DEVELOPMENT REVIEW BOARD - HYDROLOGY SECTION
 Renée Brissette, PE, Senior Engineer | 505-924-3995 rbrissette@cabq.gov

DRB Project Number: 2019-003224 Hearing Date: 01-29-2020
 Project: TR 2-A-1 & 2-B-1A New Port Industrial Park West, Unit 1 Agenda Item No: 1

Plat of  
 Tract 2-B-1-A-1 and Tract 2-B-1-A-2  
**Newport Industrial Park West, Unit 1**  
 Section 33, Township 10 North, Range 3 East, N.M.P.M.  
 City of Albuquerque, Bernalillo County, New Mexico  
 November 2019

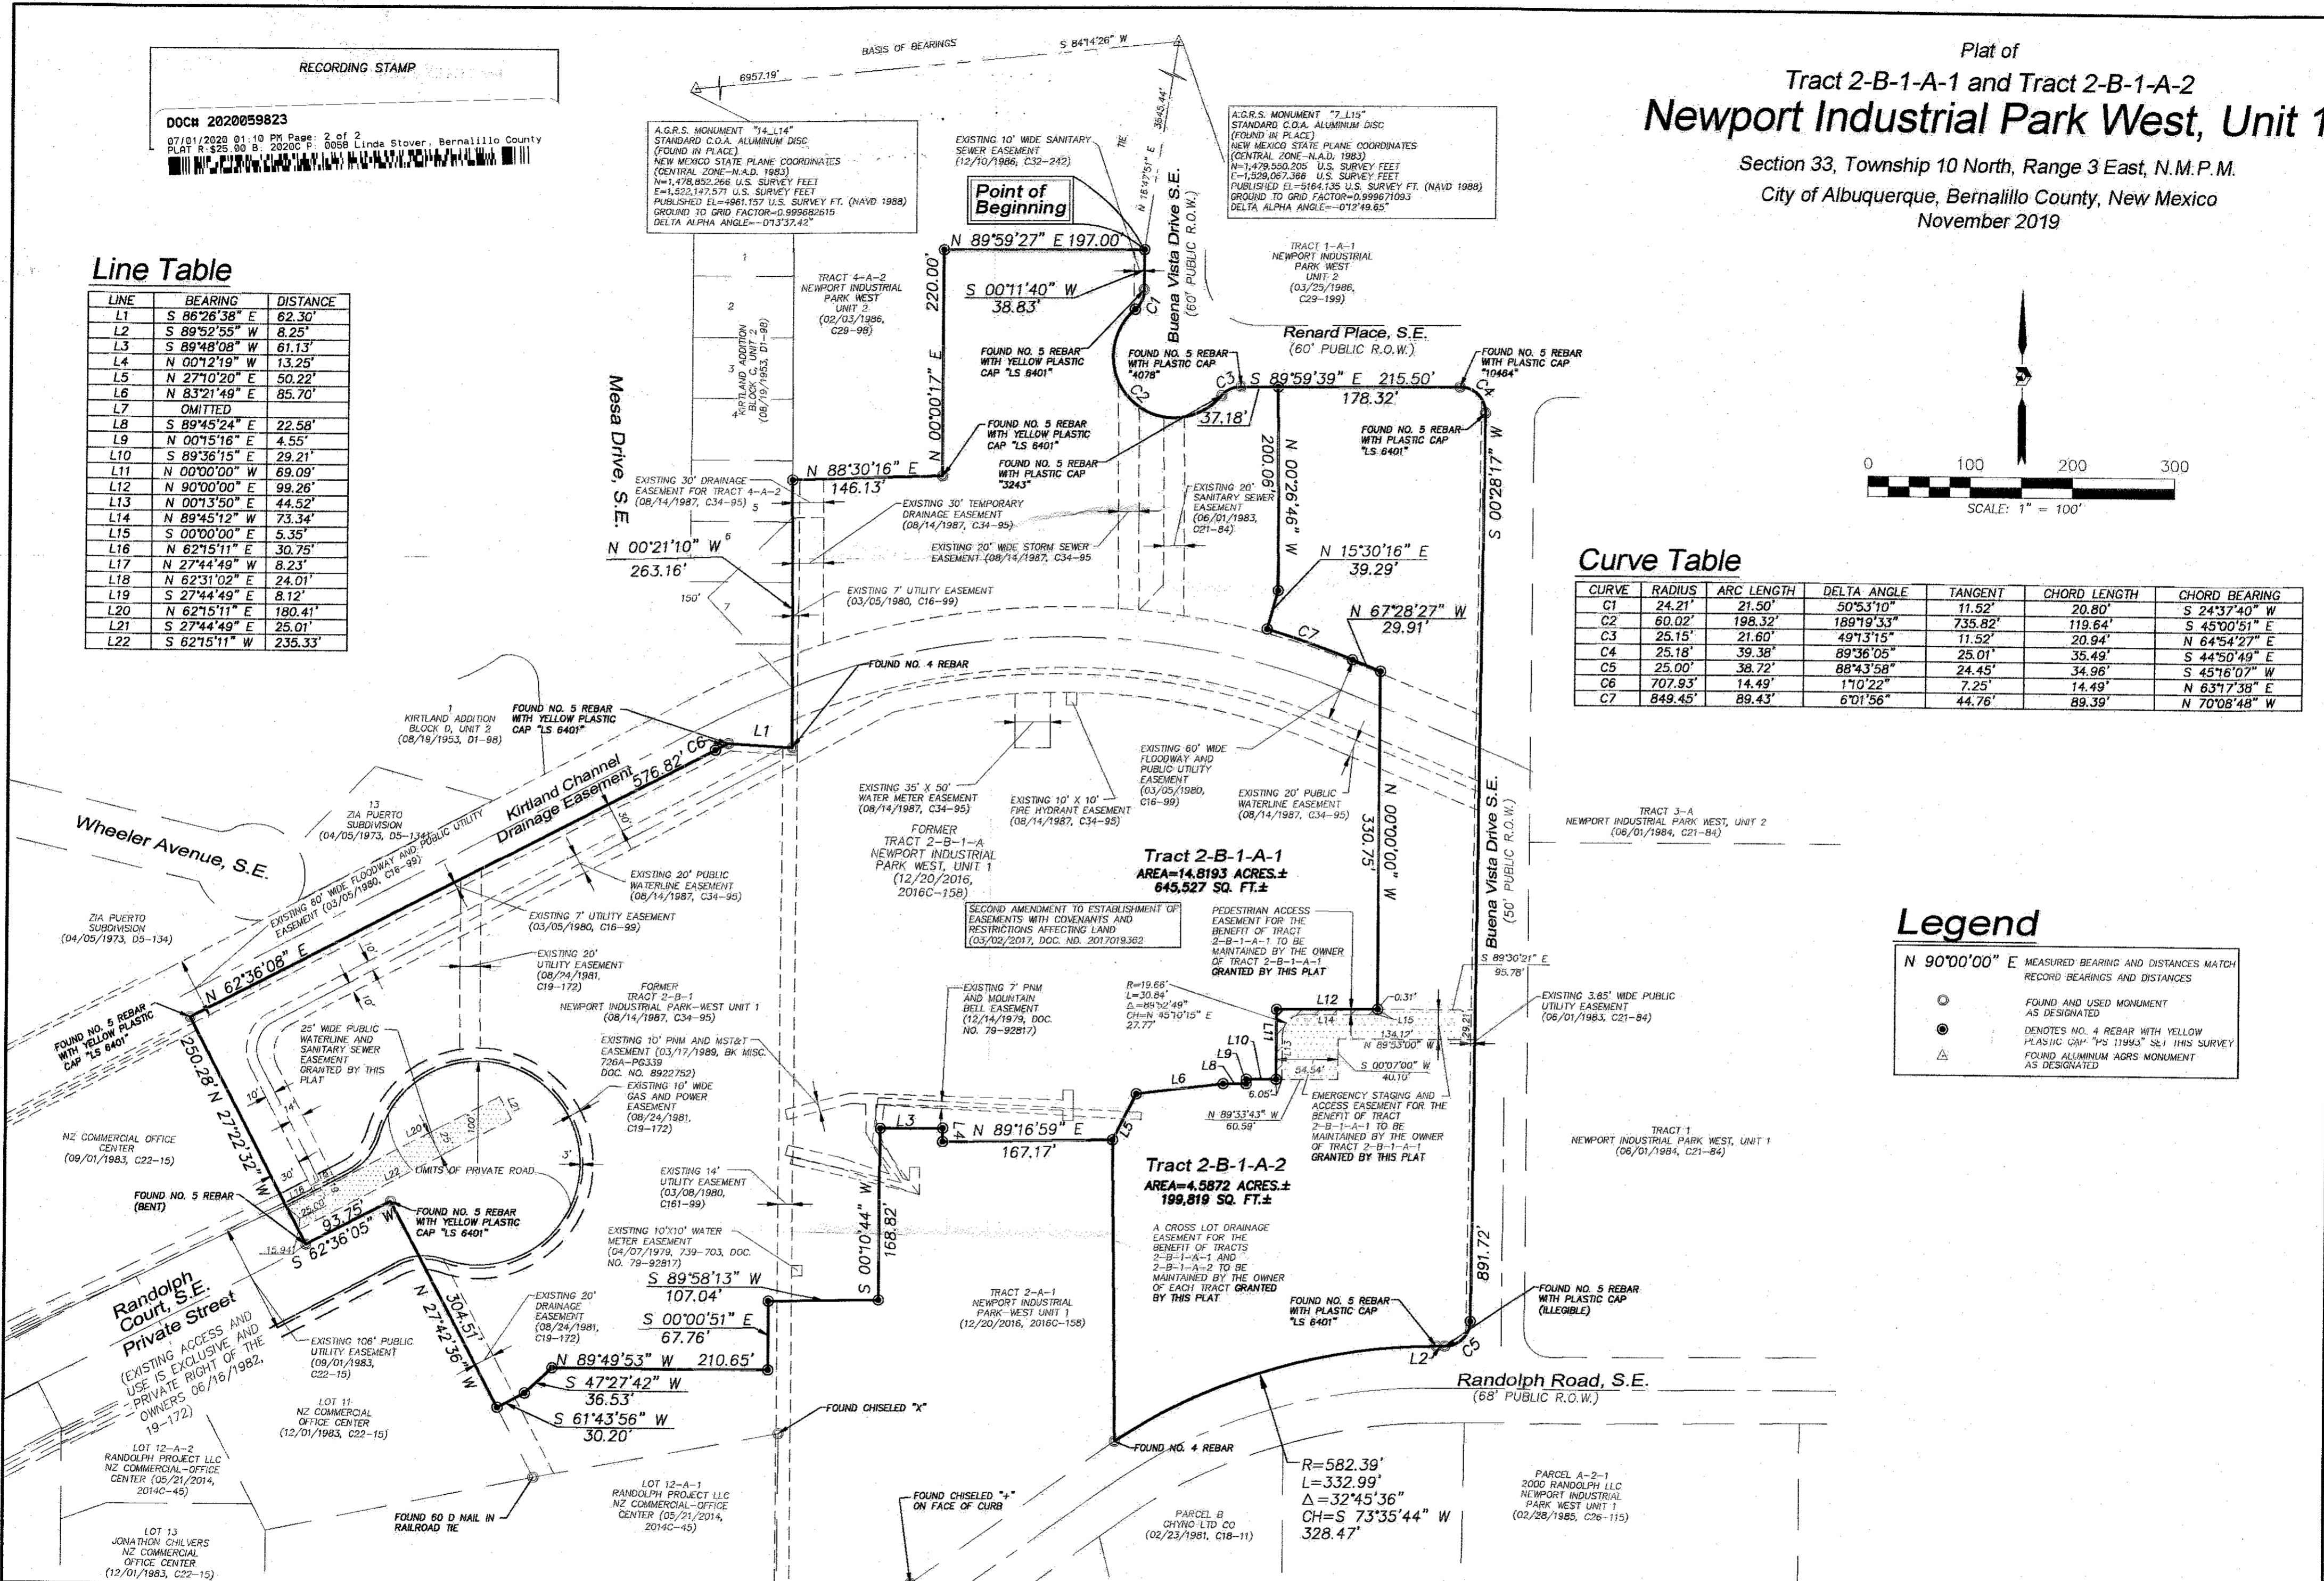
- Hydrology has no objection to the Site Plan for Building Permit.
- Plat - Add a Cross Lot Drainage Easement note specifying the beneficiary and maintenance agreement.
